Our ref: PS223670-SYD-HYD-LTR-0003-RevB2

SSD-77240466 Proposed aged care facility, 36-42 Cabbage Tree Road, Bayview, NSW
Basement design options and groundwater recharge management

Response to DPHI comments on hydrogeological matters

TITLE
STORMWATER DRAINAGE PLAN
- LOWER GROUND FLOOR PLAN

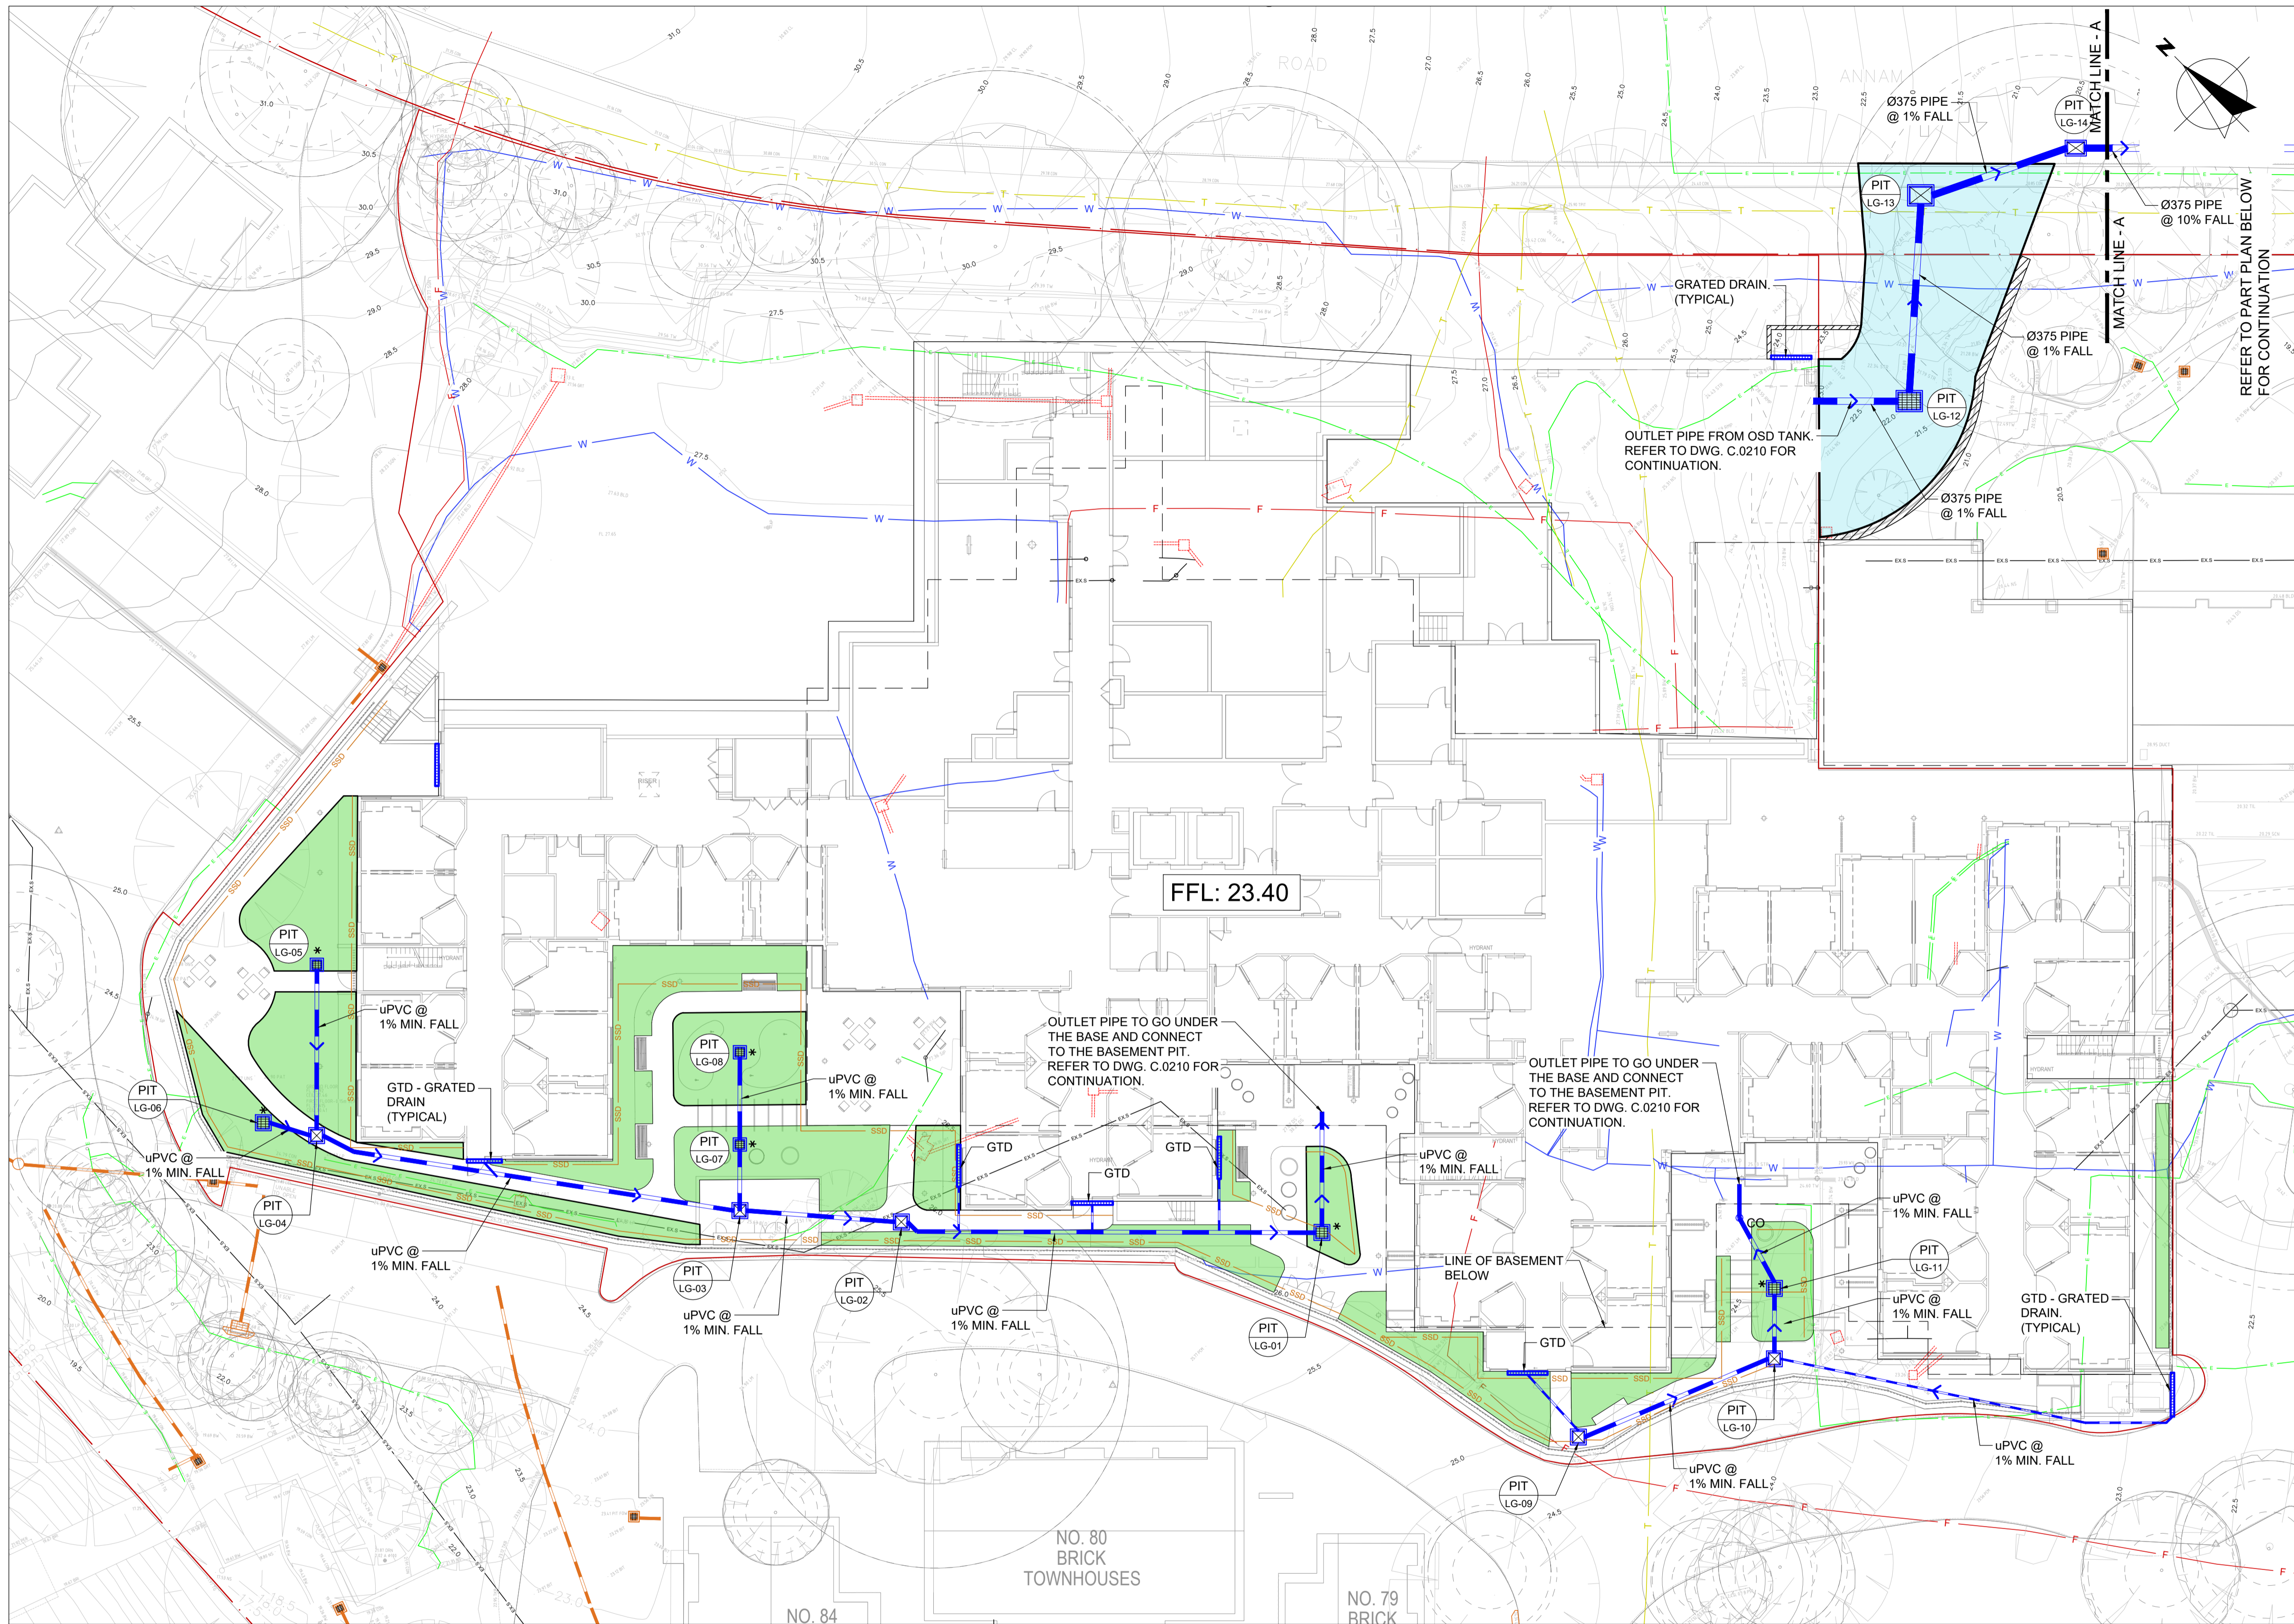
c. Engineering drawings show the basement subsoil drainage system connecting to the stormwater quality chamber, indicating mixing of groundwater and stormwater. This contradicts Appendix S1, which requires: "Separate any subsoil/groundwater drainage from the rainwater system." This inconsistency must be resolved, as mixing groundwater with stormwater can compromise treatment system performance and regulatory compliance.

d. A tanked basement is required to avoid groundwater interception and protect the downstream SEPP- listed Littoral Rainforest, thereby preventing hydrological impacts, eliminating the need for ongoing groundwater extraction and water-quality treatment, and removing risks associated with mixing stormwater and groundwater.

- separating groundwater drainage from stormwater drainage;
- reusing collected groundwater where feasible;
- re-infiltrating or returning collected groundwater to the local subsurface system where practicable;
- treating water before re-infiltration or reuse, if required; and
- monitoring groundwater levels and water quality during construction.

WSP considers the drained basement design justified and suitable for assessment of SSD-77240466. Measures such as separating groundwater and stormwater drainage, reusing or re-infiltrating collected groundwater where feasible, treating water quality if required, and monitoring can be incorporated into the design and operation to further minimise potential effects on local groundwater recharge and shallow groundwater movement.
